PLANNING AMENDMENT

Application No. *H14/0261/95/2*
 Date registered *07 JUL 1995*
 Case Officer *DR*

REPLACEMENT DWELLING AND TEMPORARY STING FOR CARAVAN

DESCRIPTION OF ORIGINAL DEVELOPMENT: Replacement dwelling and temporary siting for caravan

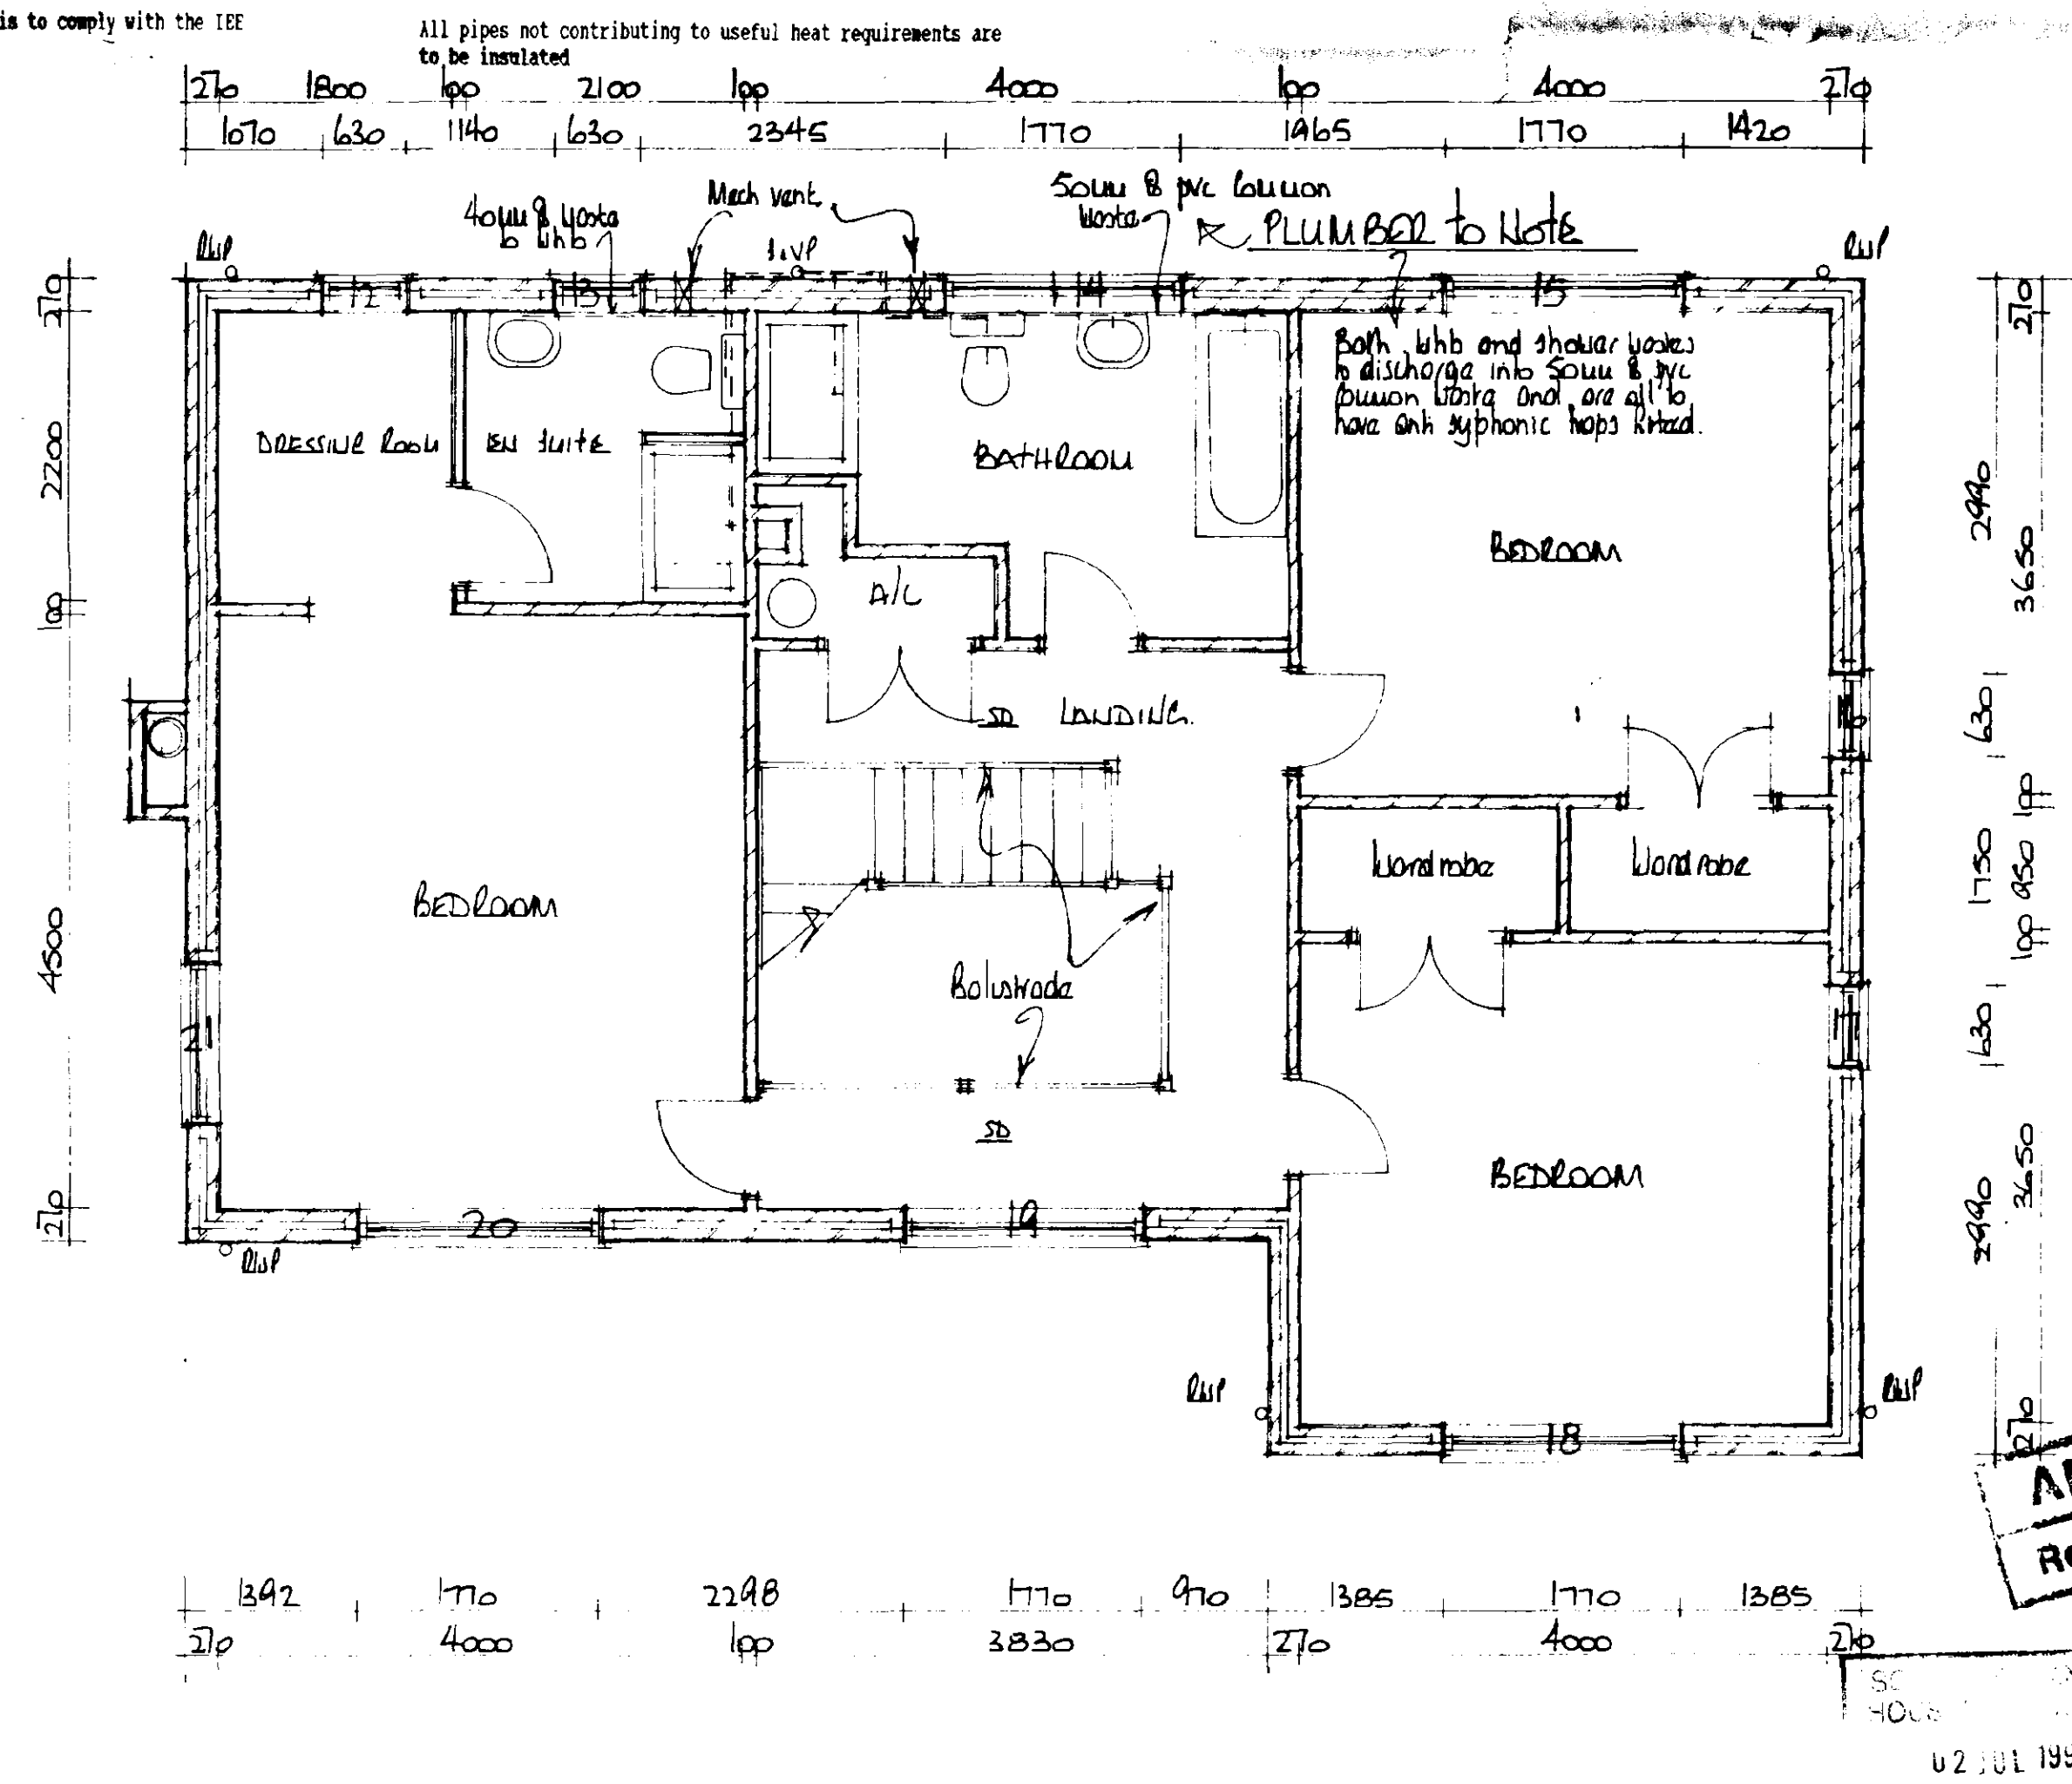
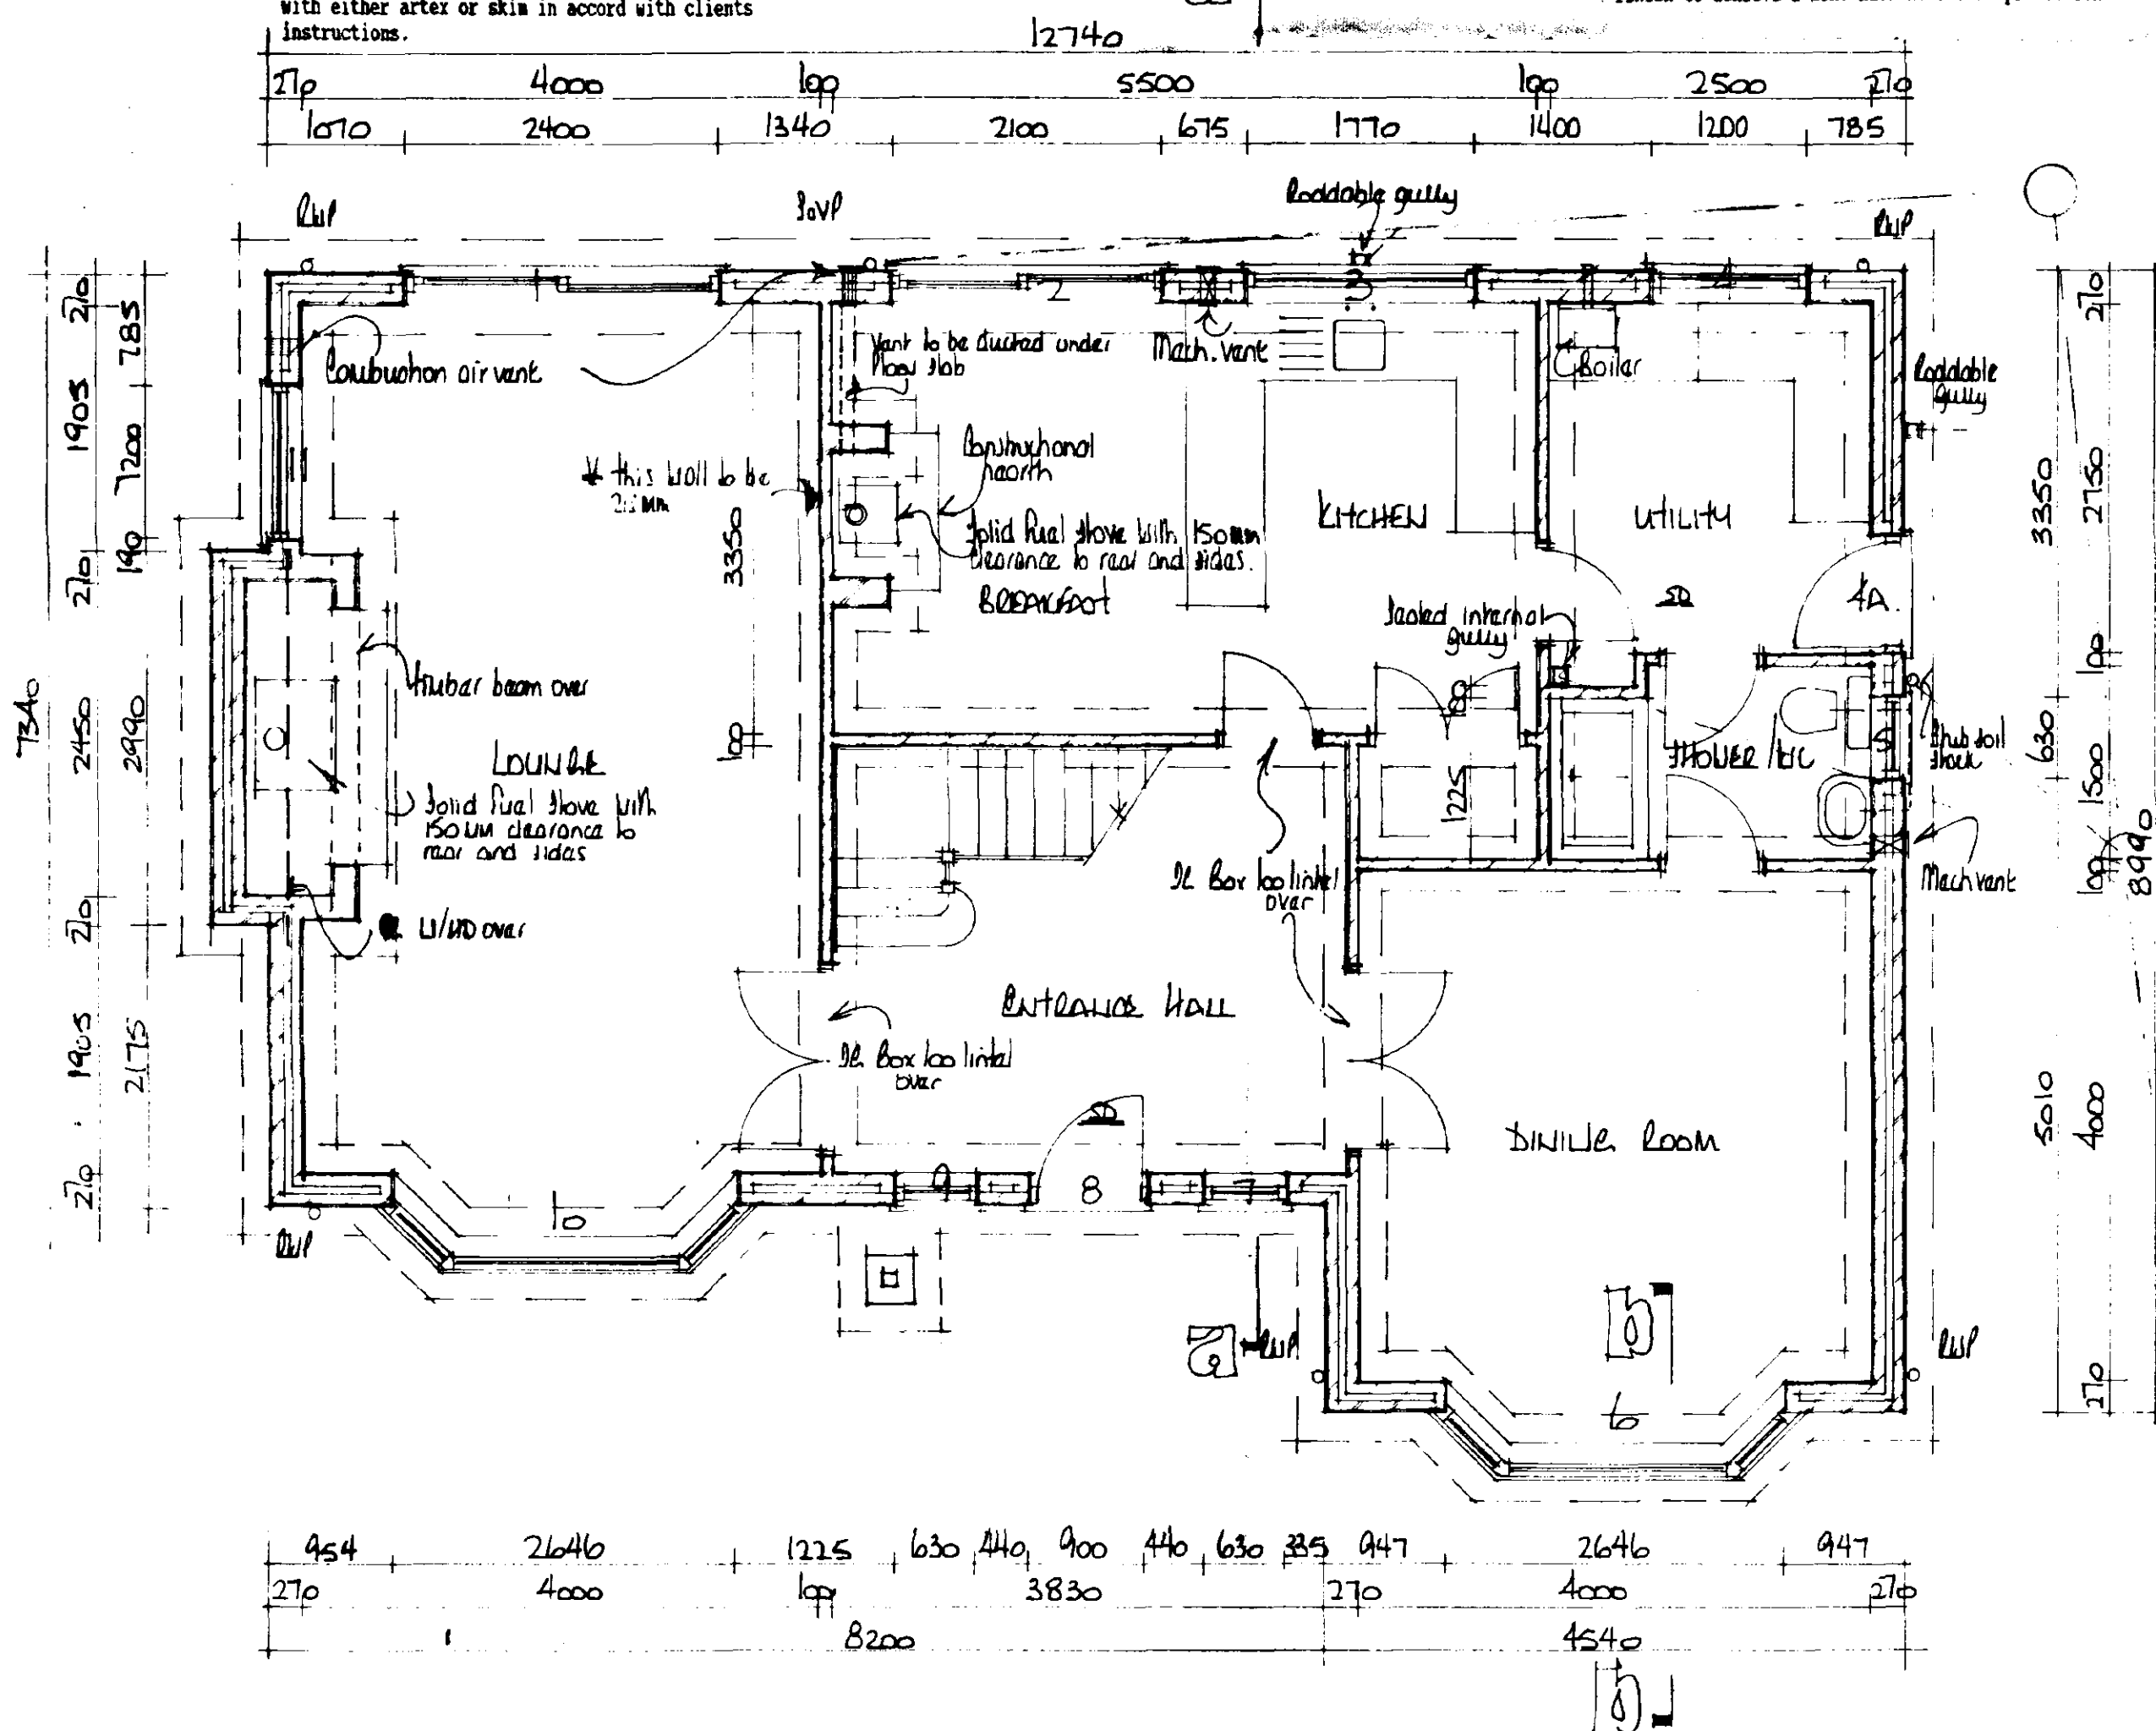
REAR EXTENSION DOOR INTO UTILITY RE POSITIONED

94/80/01/B.

AMENDMENT SUBMITTED: Rear entrance door into utility re-positioned (drawing no. 94/80/01 B)

The amended details submitted in respect of the above proposal have now been considered, and I am able to inform you that there are no objections to the amendment being implemented to the extent described above.

Drawing Title
Block Plan

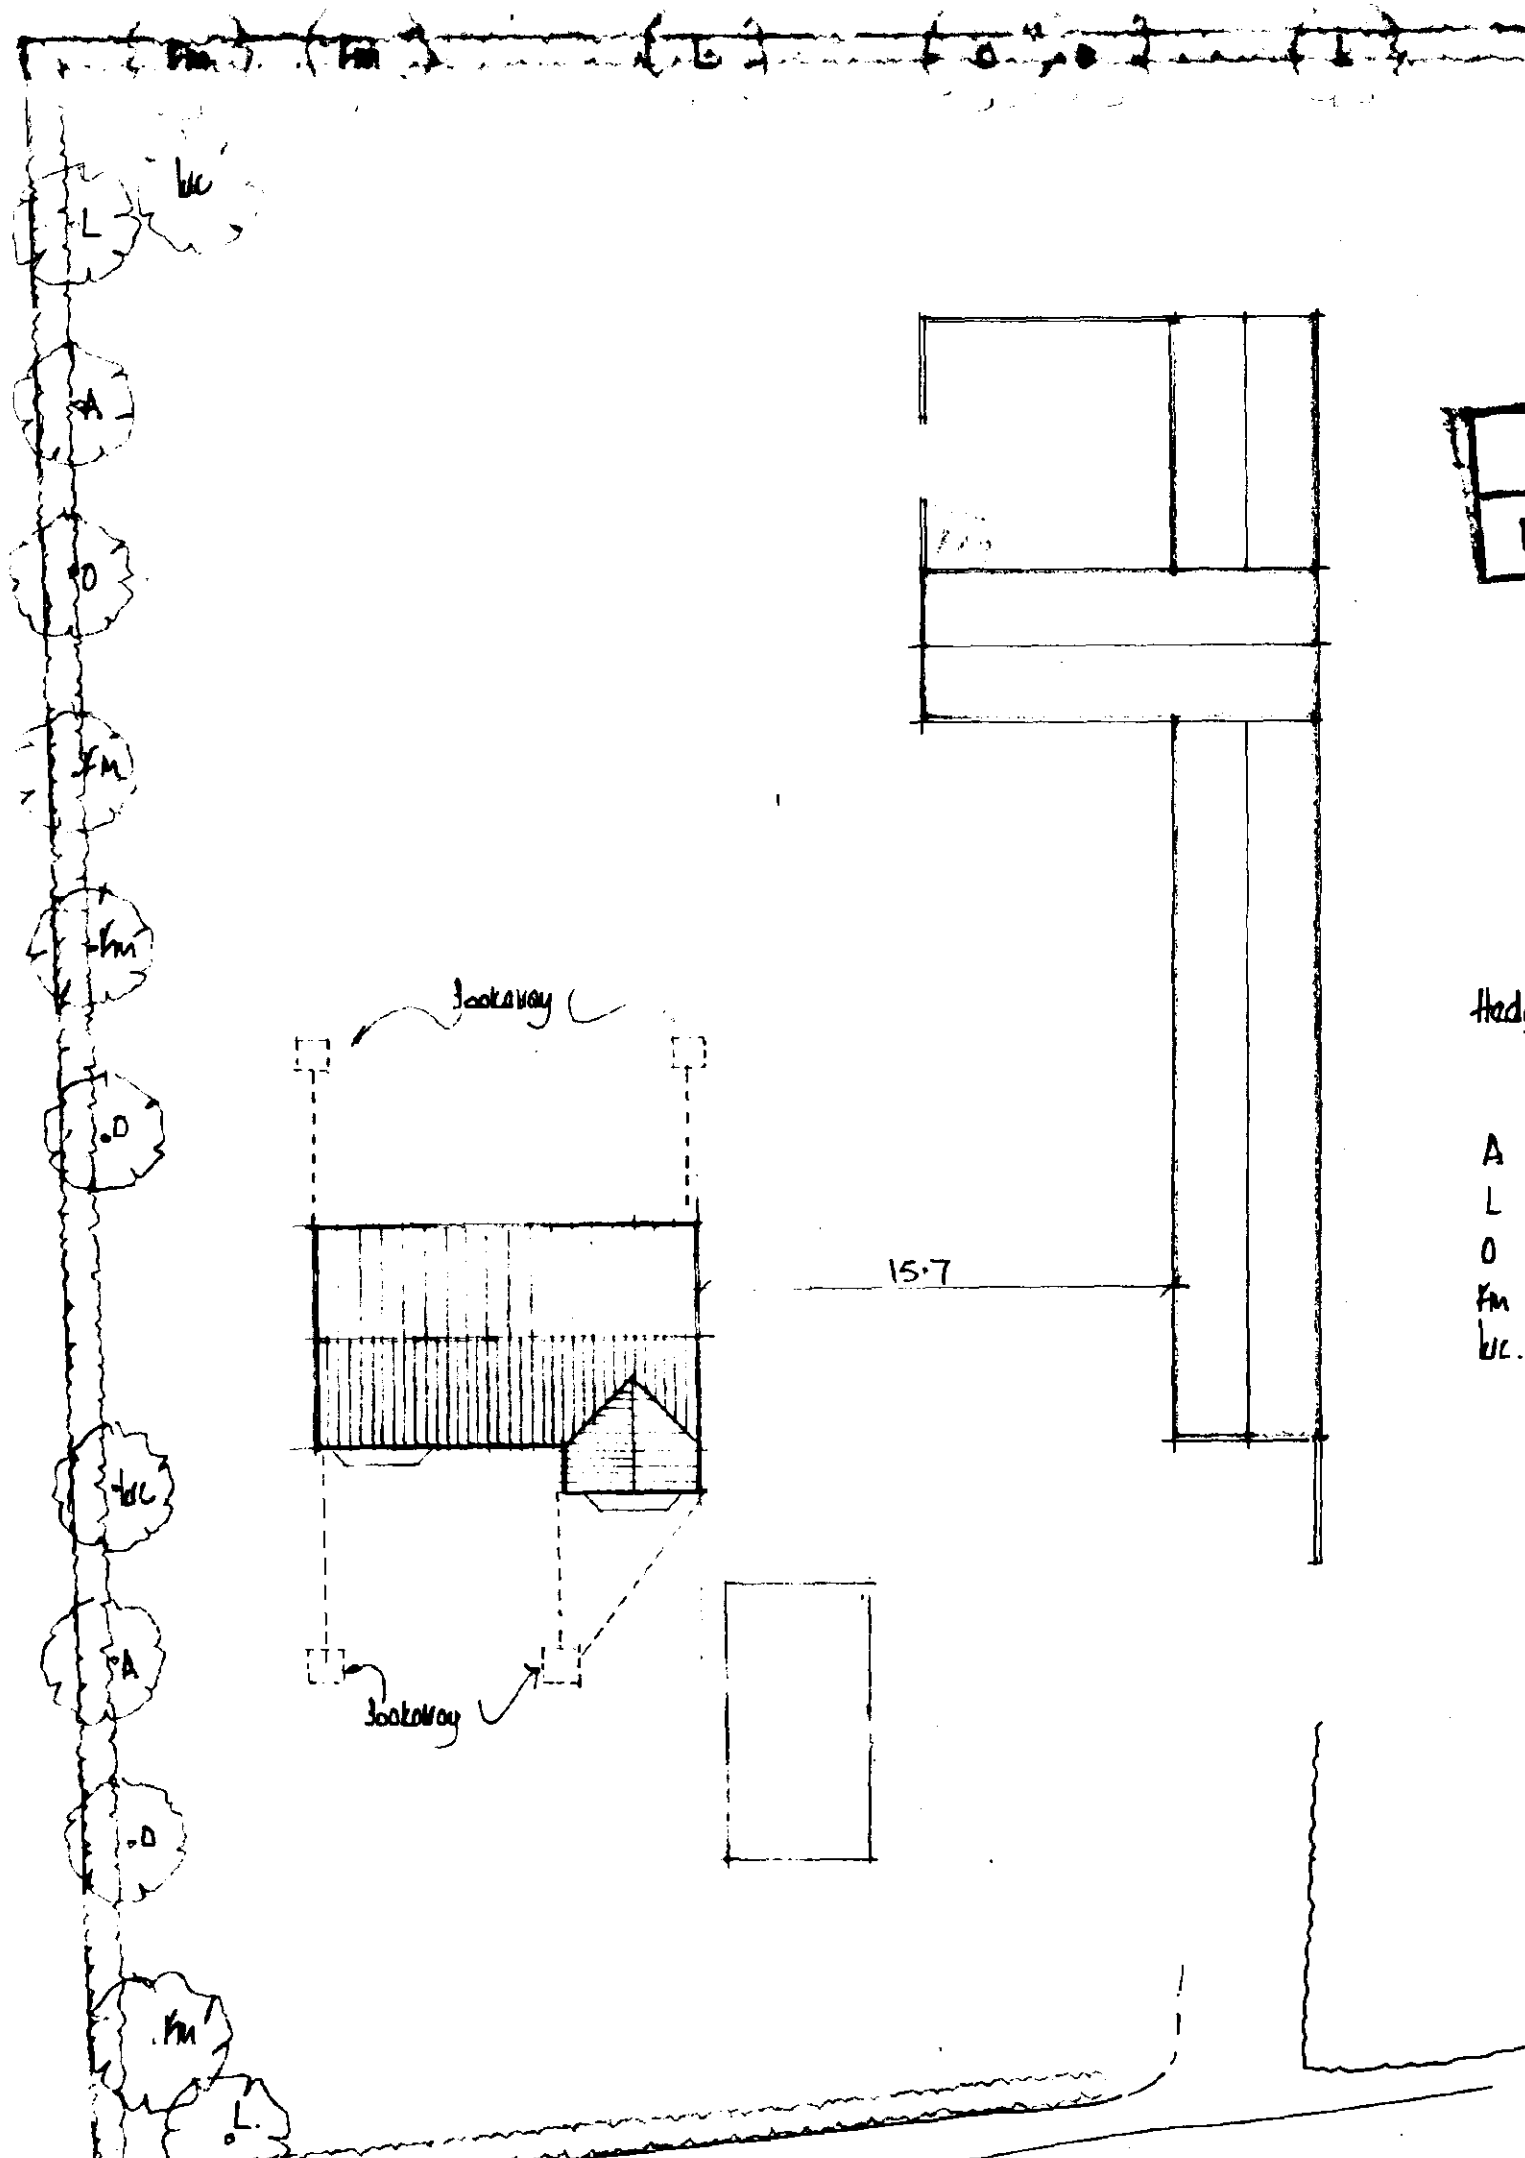
RESITING OF DWELLING.

94/80/03

Amendment: Resiting of dwelling
(drawing number 94/80/03.B)

The amended details submitted in respect of the above proposal have now been considered, and I am able to inform you that there are no objections to the amendment being implemented to the extent described above.
